City of Portland, Maine - Building or Use Permit Application

Permit No: 04-036	Issue Date: MAY 12 2004	CBL: 032 P004001
----------------------	----------------------------	---------------------

Proposed Project Description: Build 320 sq. Ft flat roof deck.	FIRE DEPT: <input checked="" type="checkbox"/> Approved <input type="checkbox"/> Denied INSPECTION: Use Group: U Type: 35 Signature: [Signature] Signature: [Signature] PEDESTRIAN ACTIVITIES DISTRICT (P.A.D.) Action: <input type="checkbox"/> Approved <input type="checkbox"/> Approved w/Conditions <input type="checkbox"/> Denied Signature: Date:
-------------------------------------------------------------------	--------------------------------------------------------------------------------------------------------------------------------------------------------------------------------------------------------------------------------------------------------------------------------------------------------------------------------------------------------------------------

DECK AS BUILT

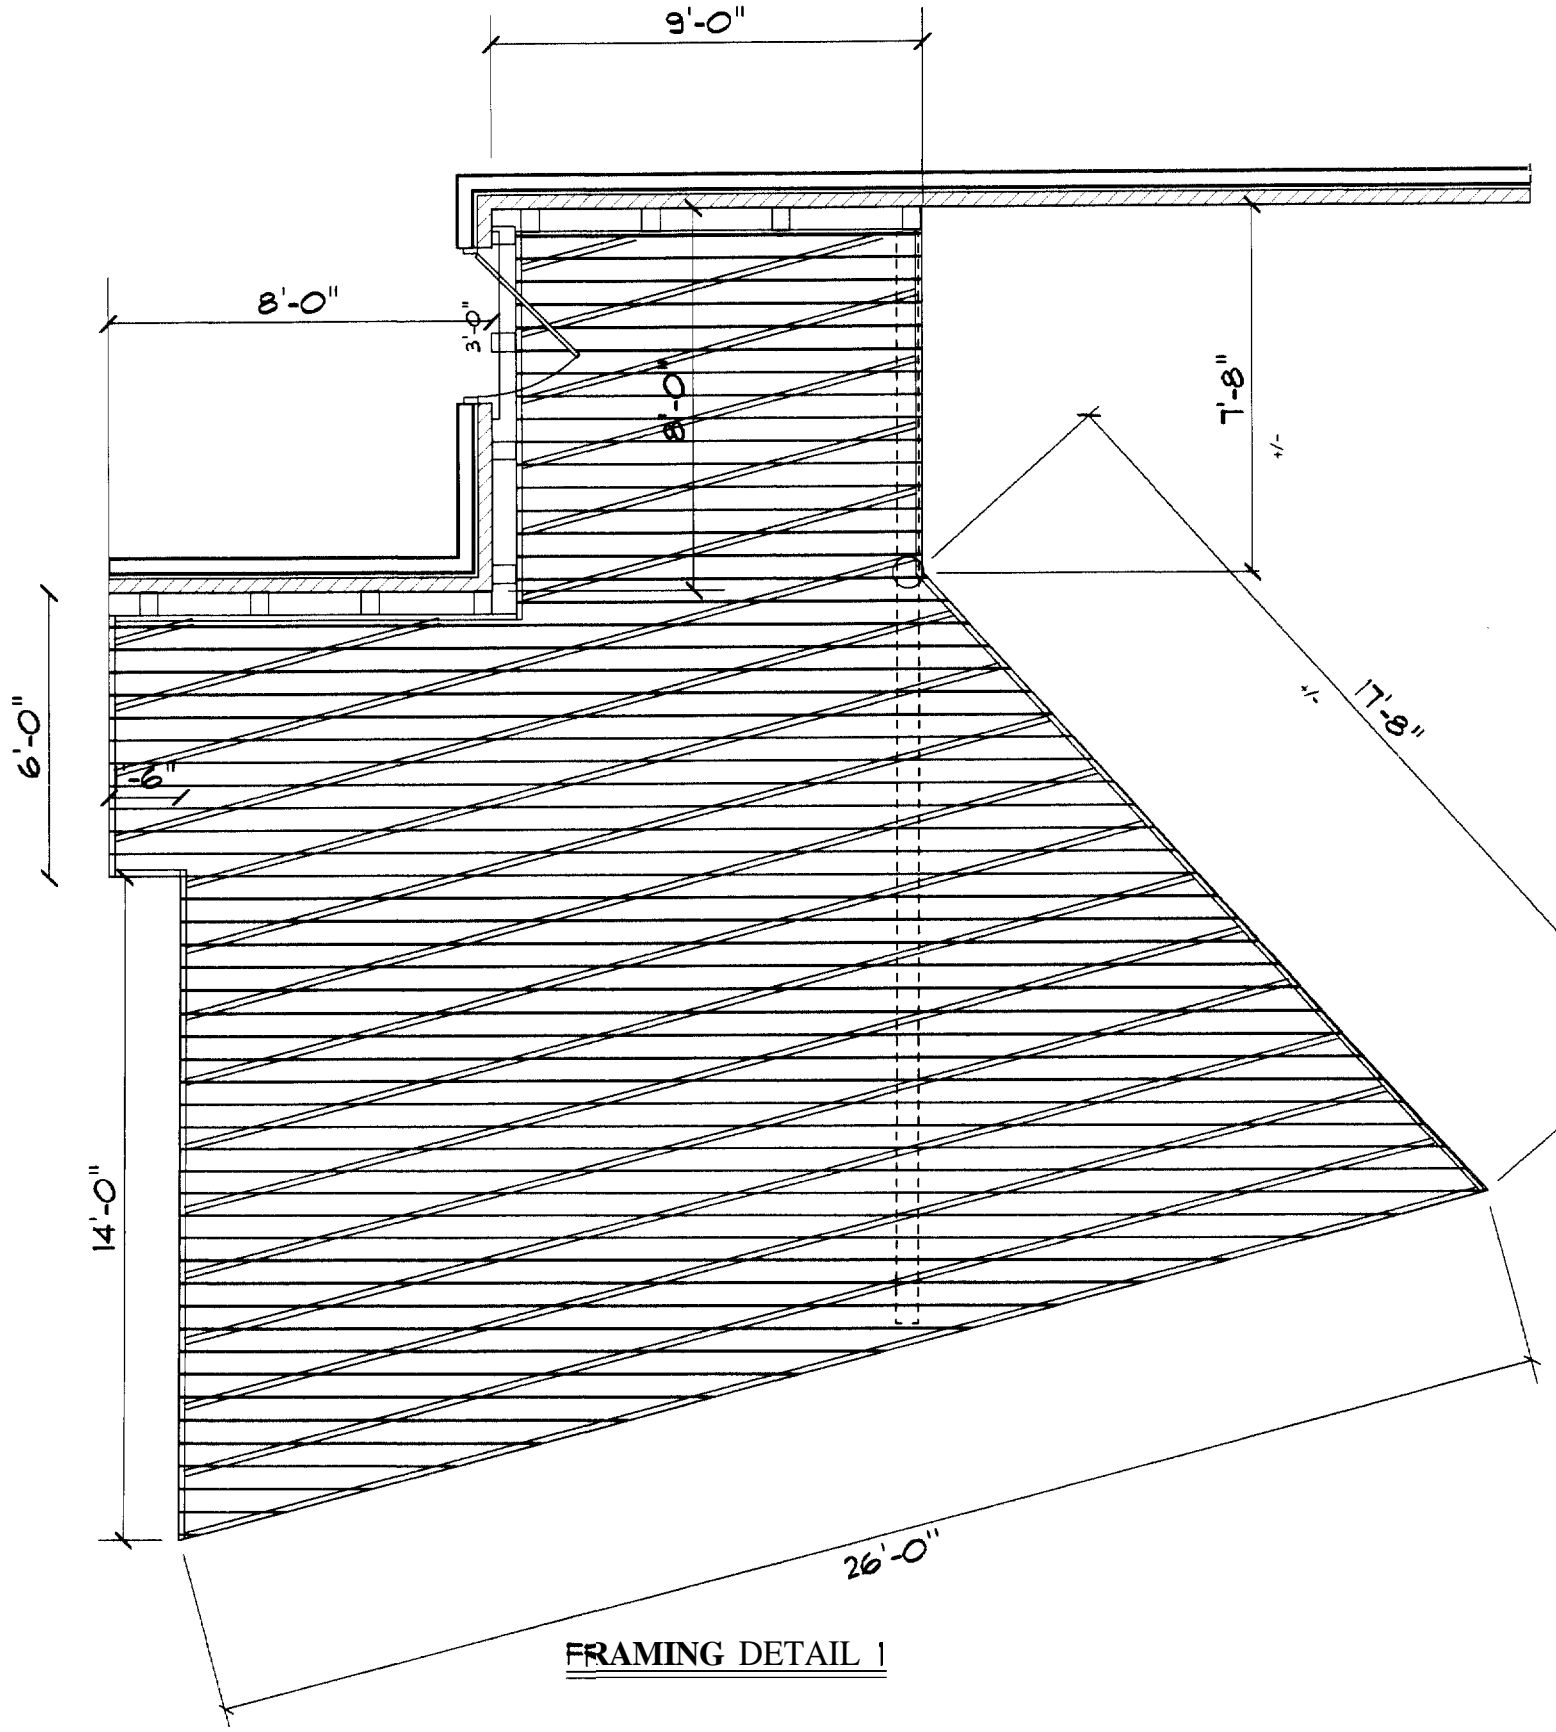
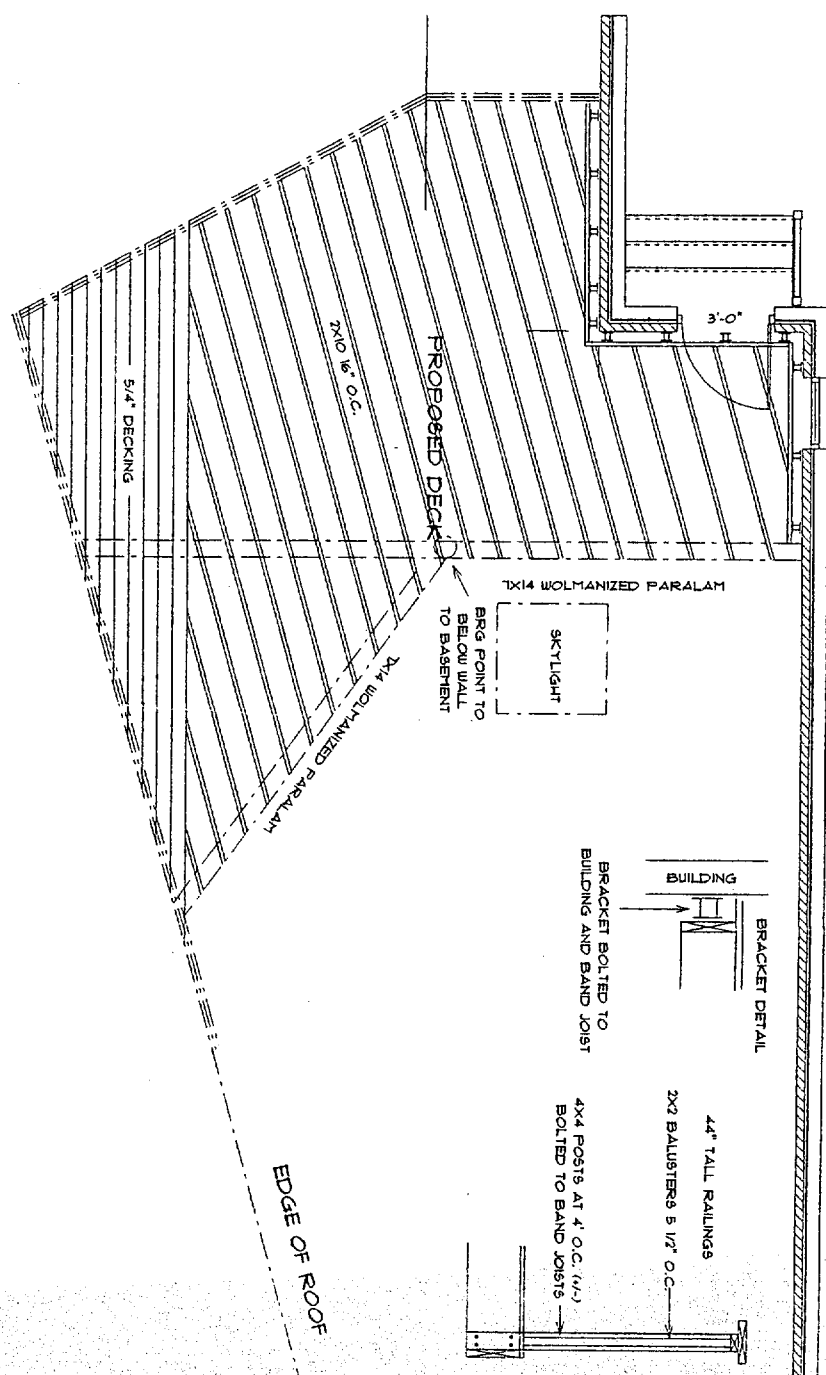
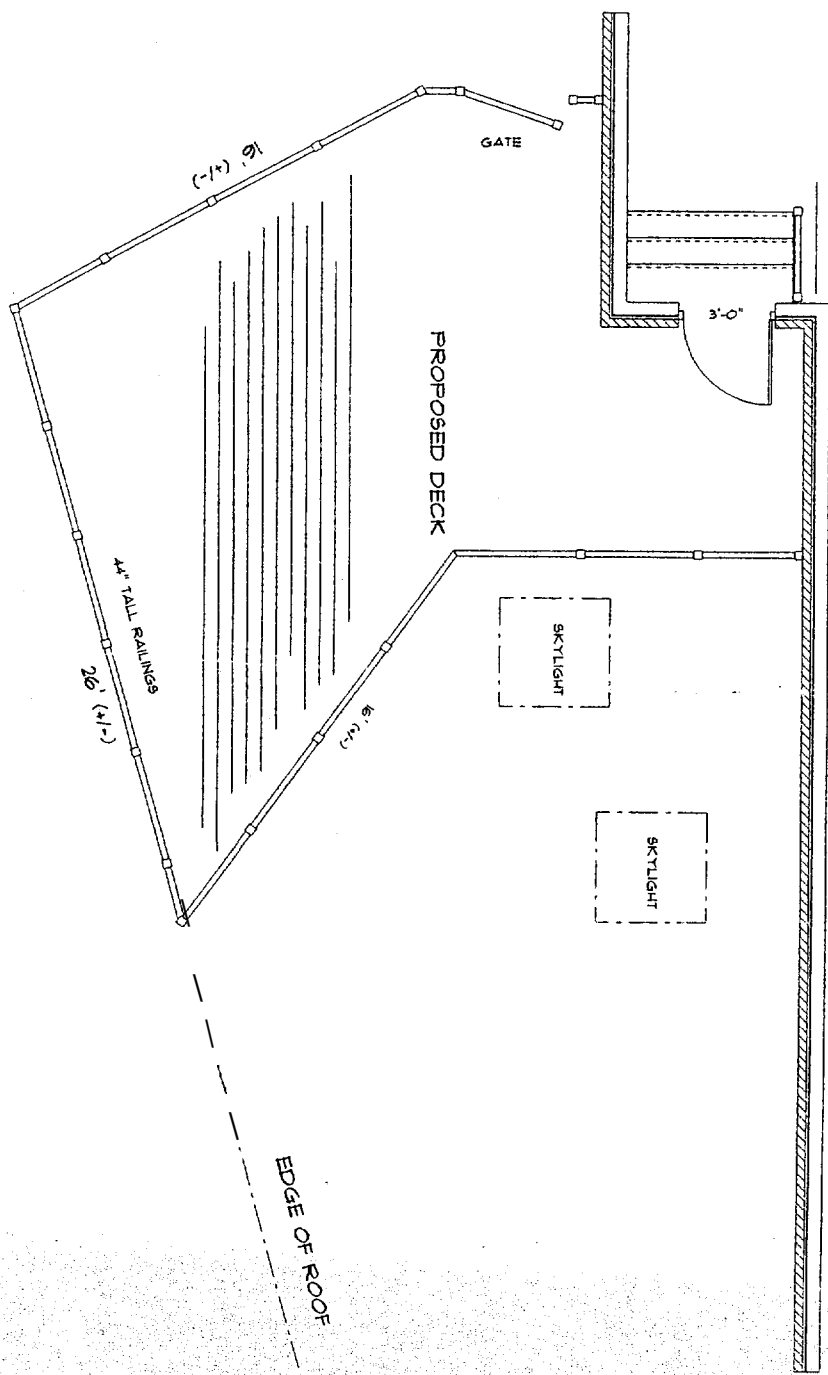
Comments: 04/27/2004-mjn: Plan includes a gate that goes onto an unprotected roof. Left a message with the owner that this need to be discussed
